**A66 Northern Trans-Pennine Project  
TR010062**

**4.5 Statement of Common Ground  
with Historic England**

**4.5 STATEMENT OF COMMON GROUND WITH  
HISTORIC ENGLAND**

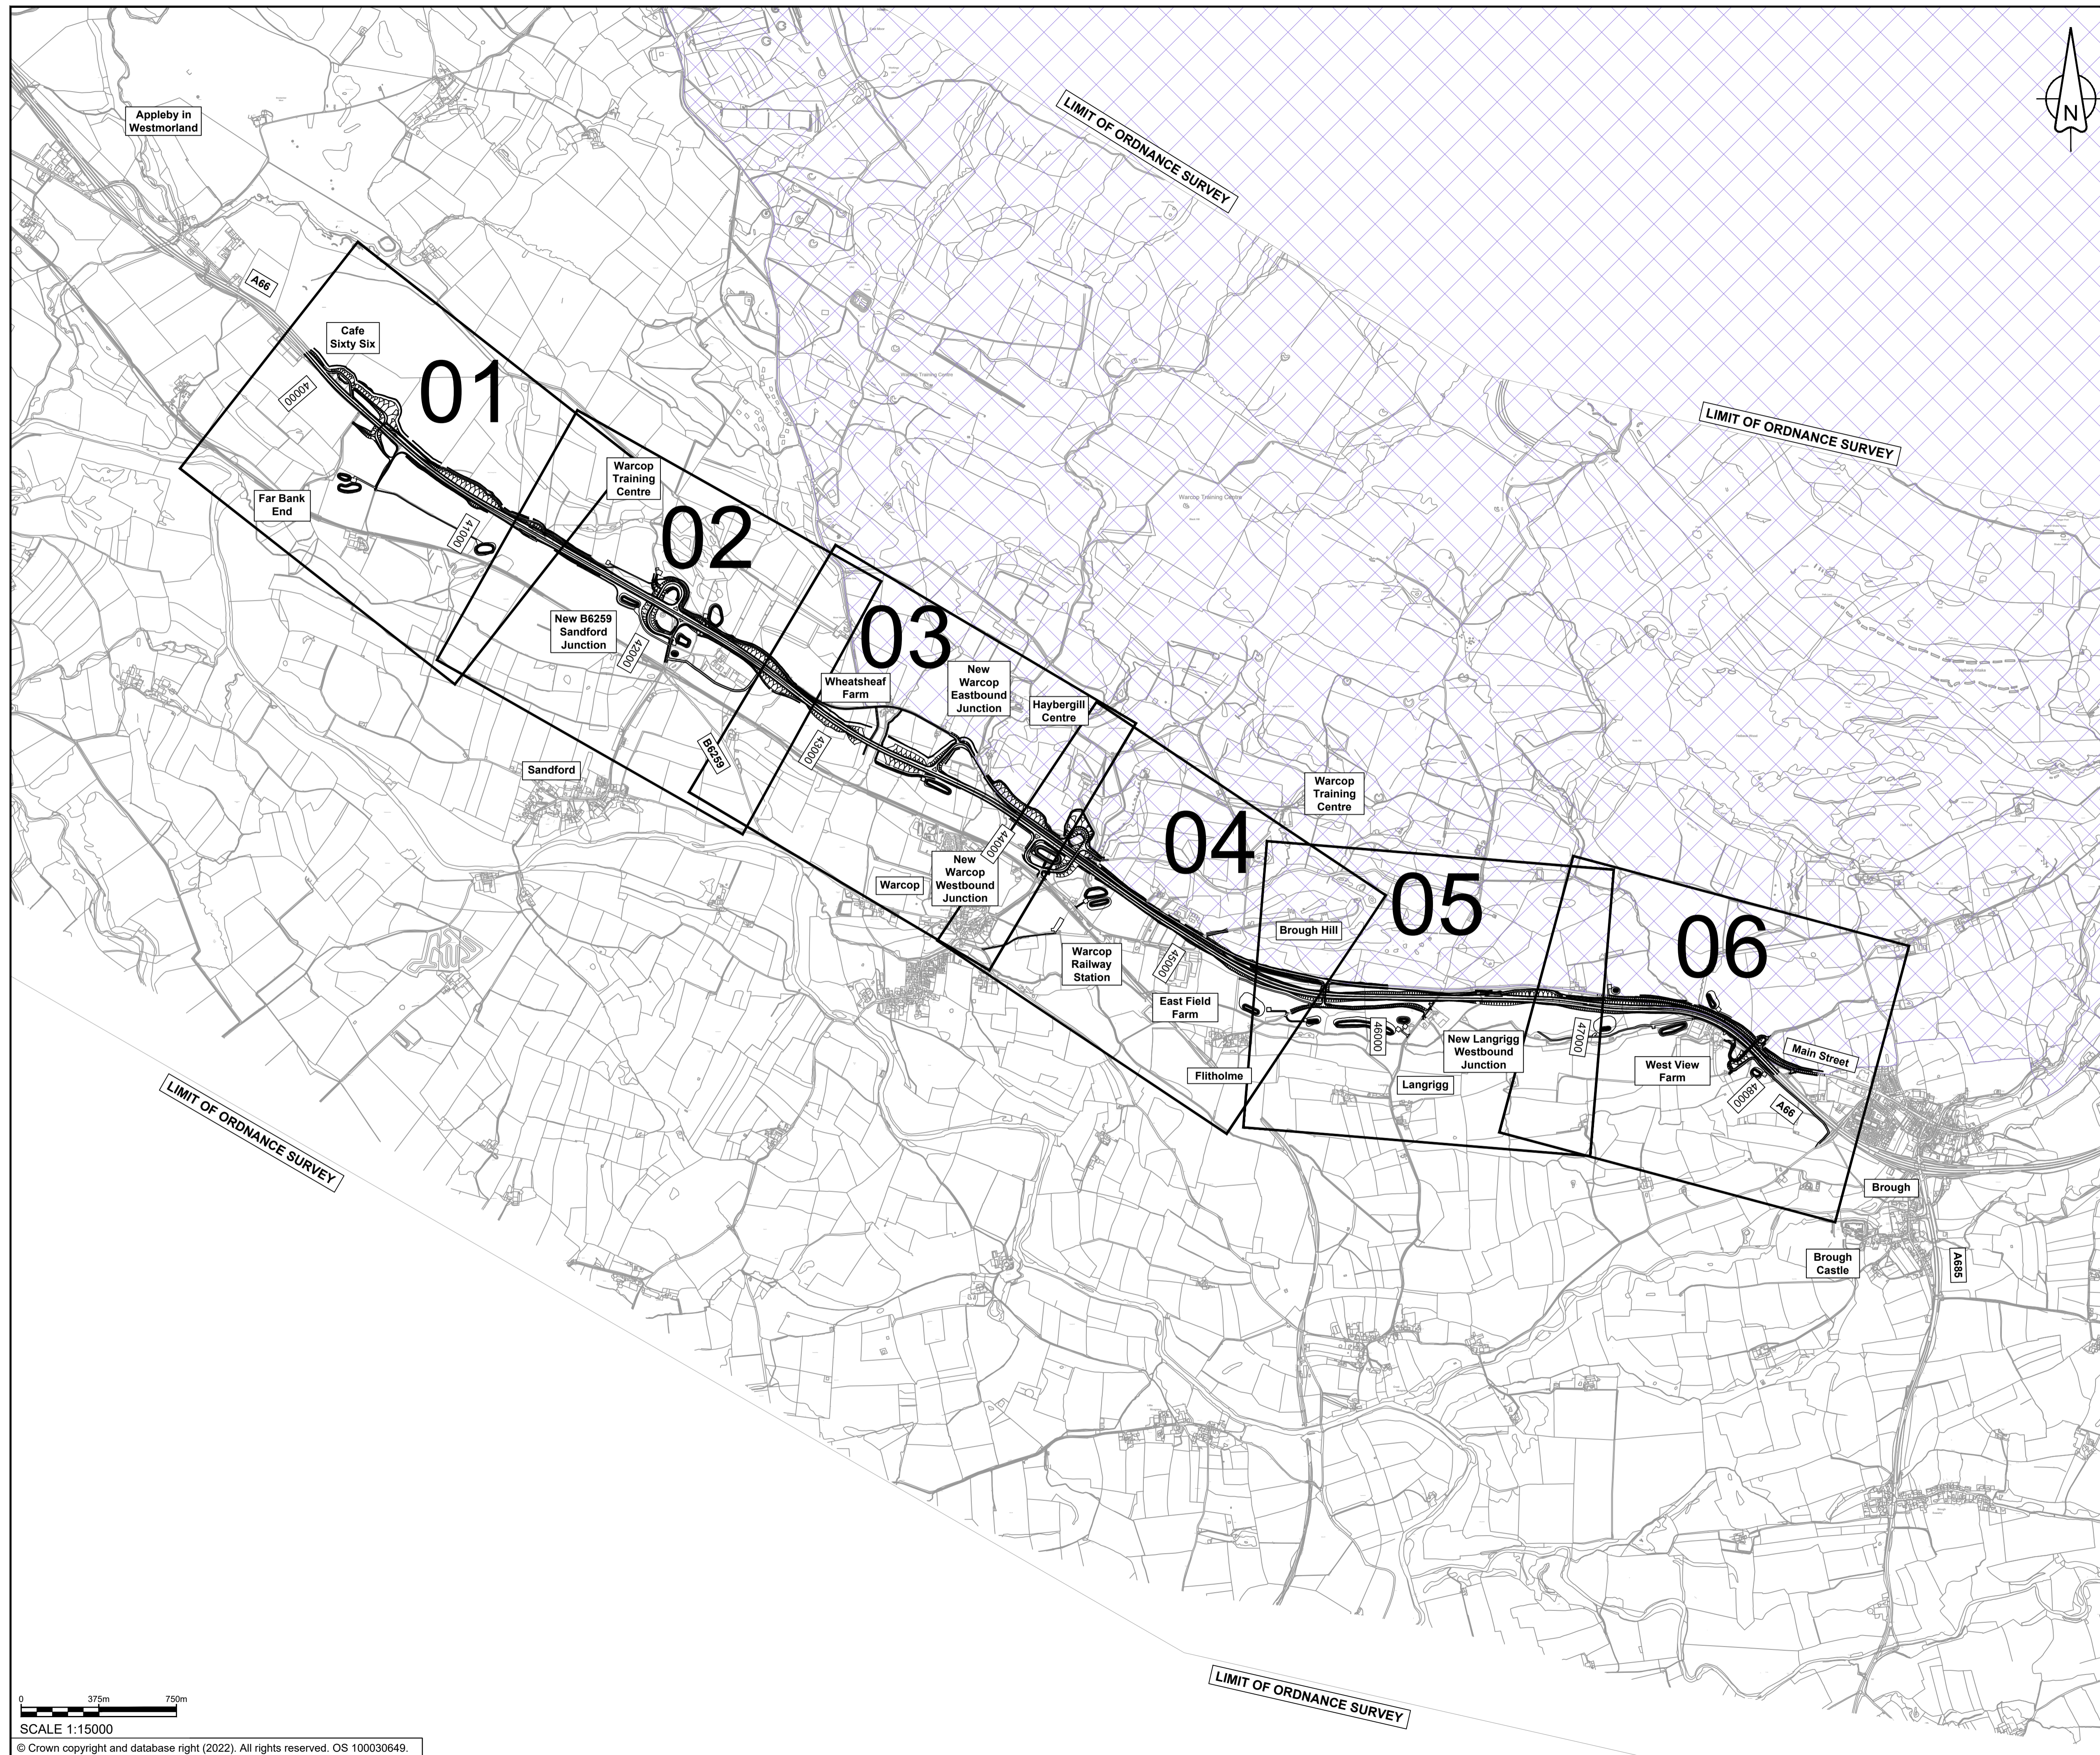
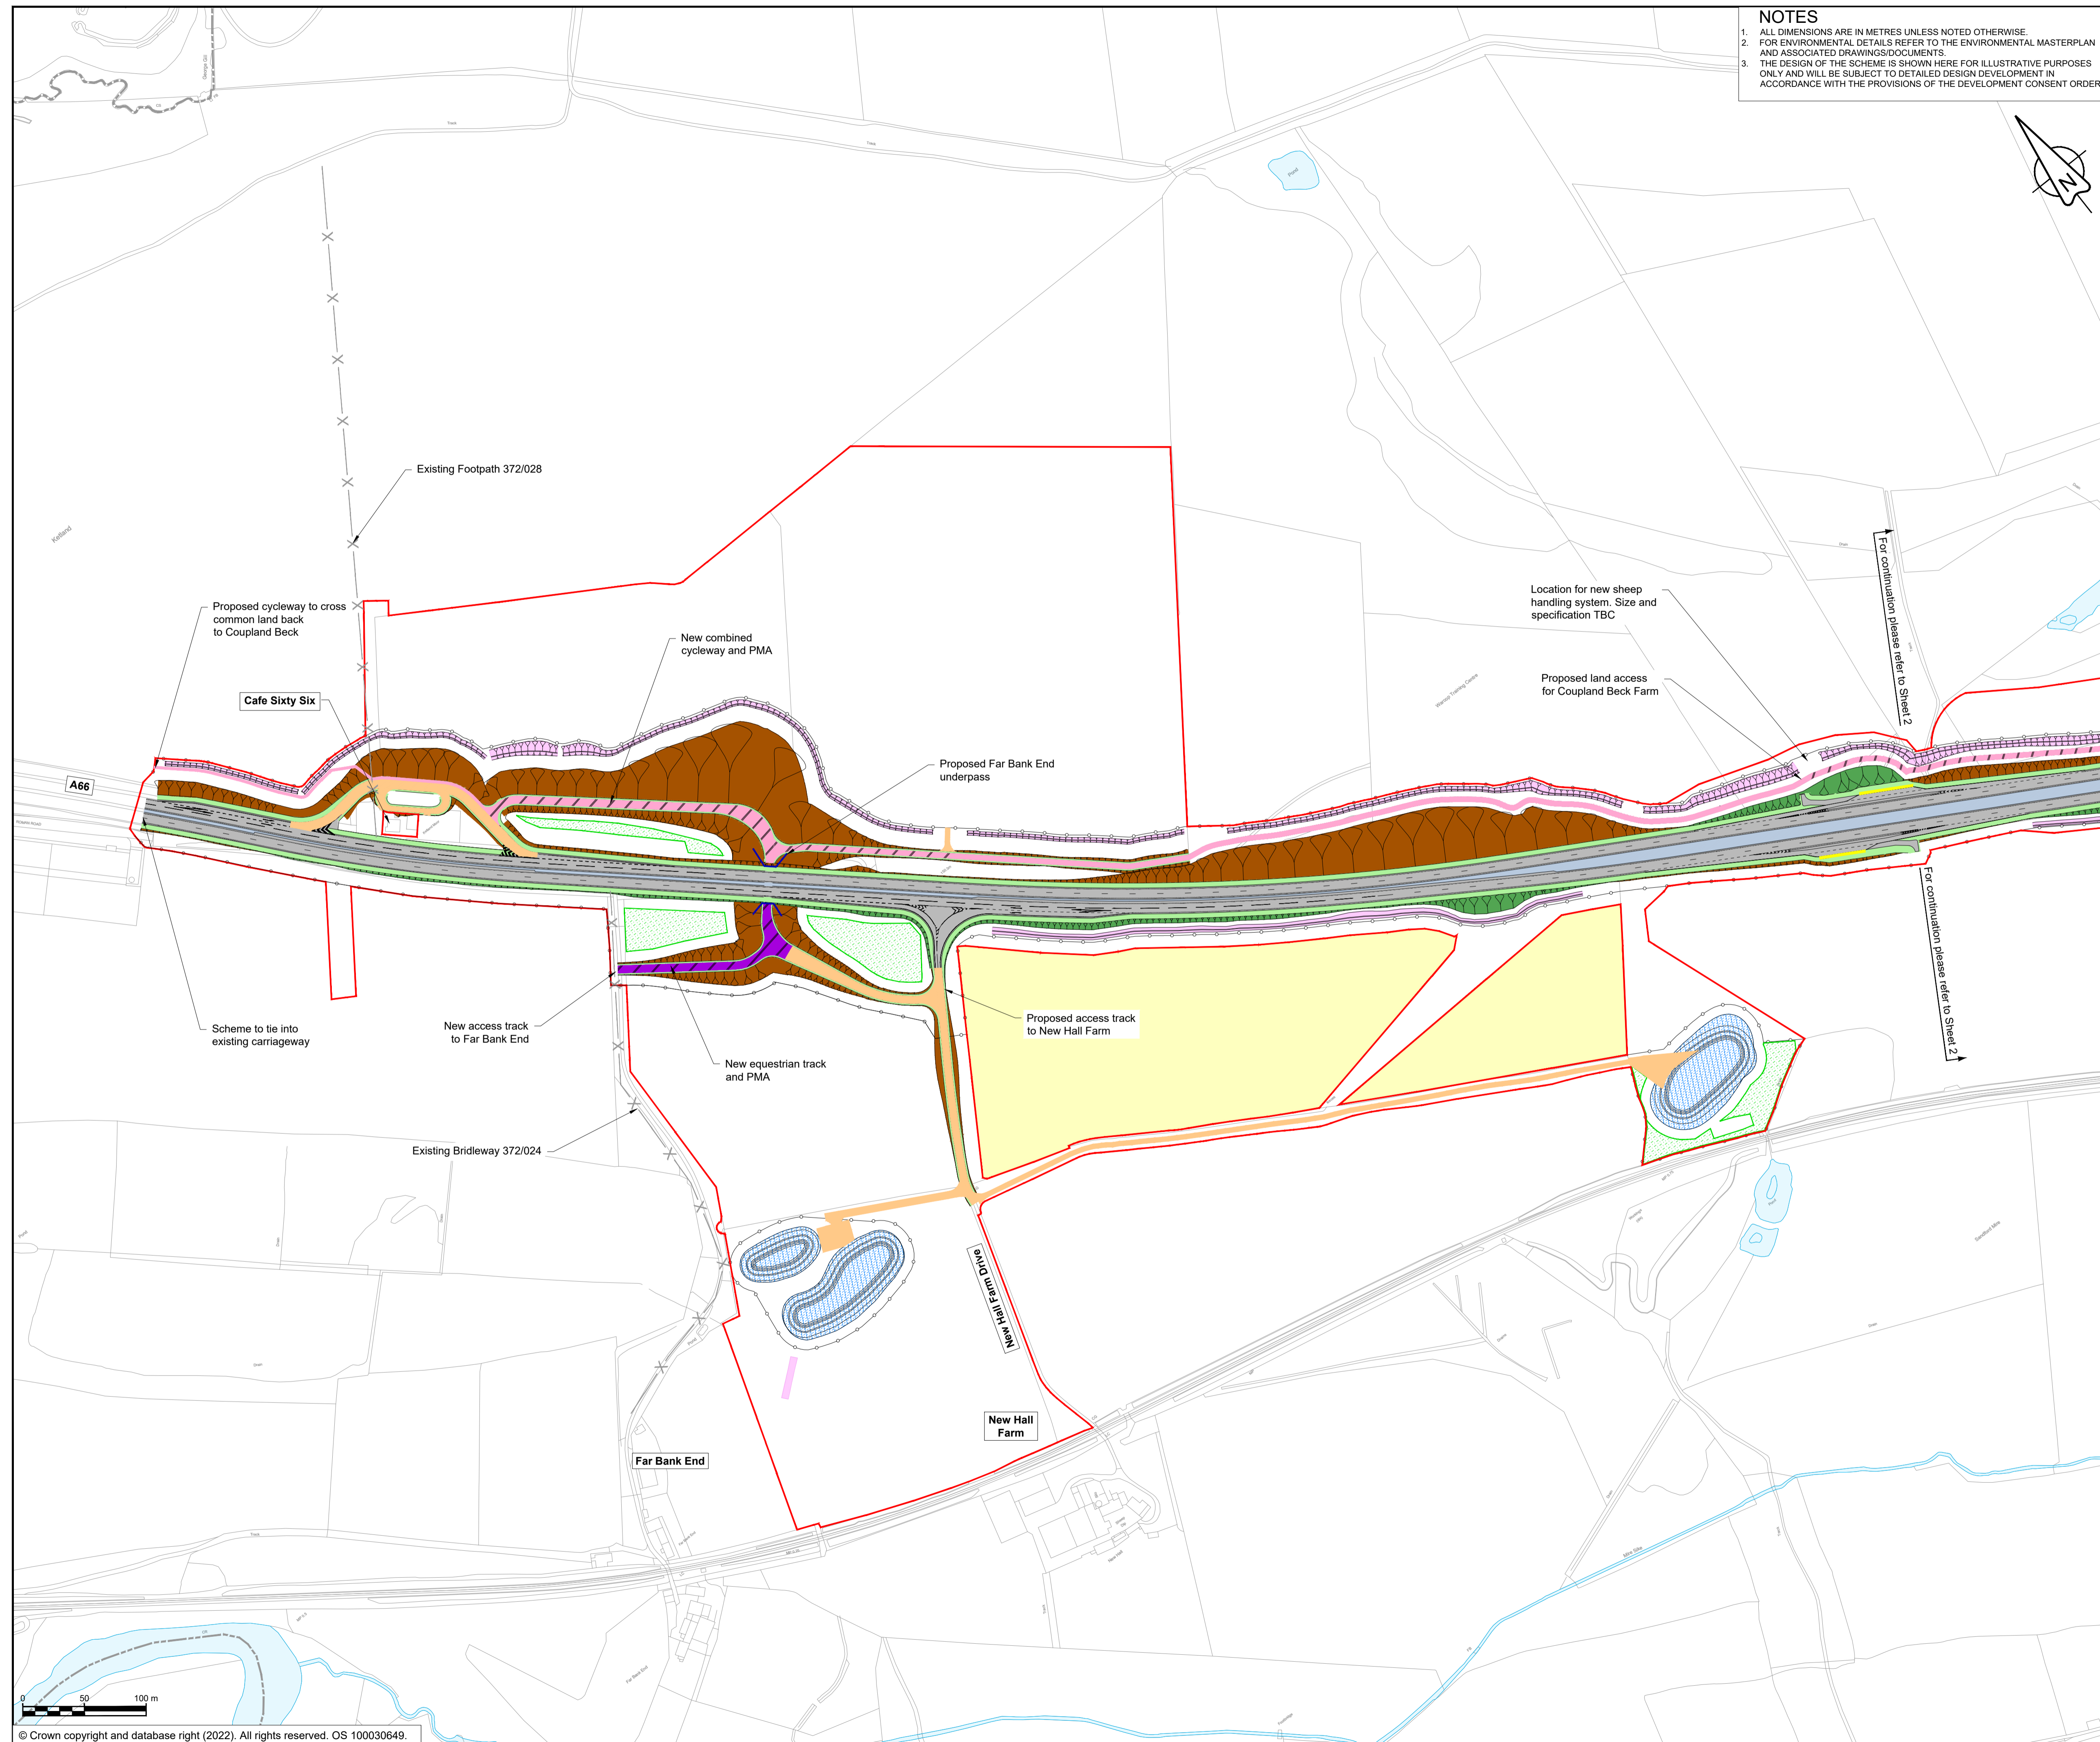
Appleby to Brough	Historic England Response to Consultation (Appendix)	The plan of the 'Warcop eastbound' junction on sheet 2 of the General Arrangement Drawings shows a construction compound immediately to the east of NHLE 1019208 (Warcop	The construction compound identified by HE (to the east of NHLE 1019208) does not sit on a scheduled area and consequently, it is not believed that there will be significant.	Under discussion	13.06.2022

Issue	Document References (if relevant)	Historic England Position	National Highways Position	Status	Date
		<p>Roman camp and length of Roman road, 285m southwest of Moor House). The potential of this compound to impact on archaeological features associated with the Roman camp needs to be investigated before its location can be confirmed.</p> <p>The PEI Report identifies significant adverse impacts on NHLE 1019208 (Warcop Roman camp and length of Roman road, 285m south west of Moor House). We would be looking for mitigation of these impacts, as far as possible, by design; failing this, through preservation by record.</p>	<p>impacts associated with the location of this compound.</p> <p>Cultural Heritage mitigation is detailed within the Environmental Management Plan (EMP) (Application Document Reference 2.7). This includes the provision that no part of the Project can start until the Detailed Heritage Mitigation Strategy (HMS) is further developed, and subject to stakeholder consultation. This will include:</p> <ul style="list-style-type: none"> <li>• The strategy for the archaeological works, summarising the work undertaken to date, the research agenda and the approach to mitigation proposed.</li> <li>• The Overarching Written Scheme of Investigation (OWSI) which will set out the framework for the archaeological works and will be used as a reference for the Site-Specific Written Schemes of Investigation (SSWSI) which will be produced in advance of the commencement of the work.</li> <li>• Requirements for SSWSI to be prepared, detailing type and location of mitigation required.</li> </ul>
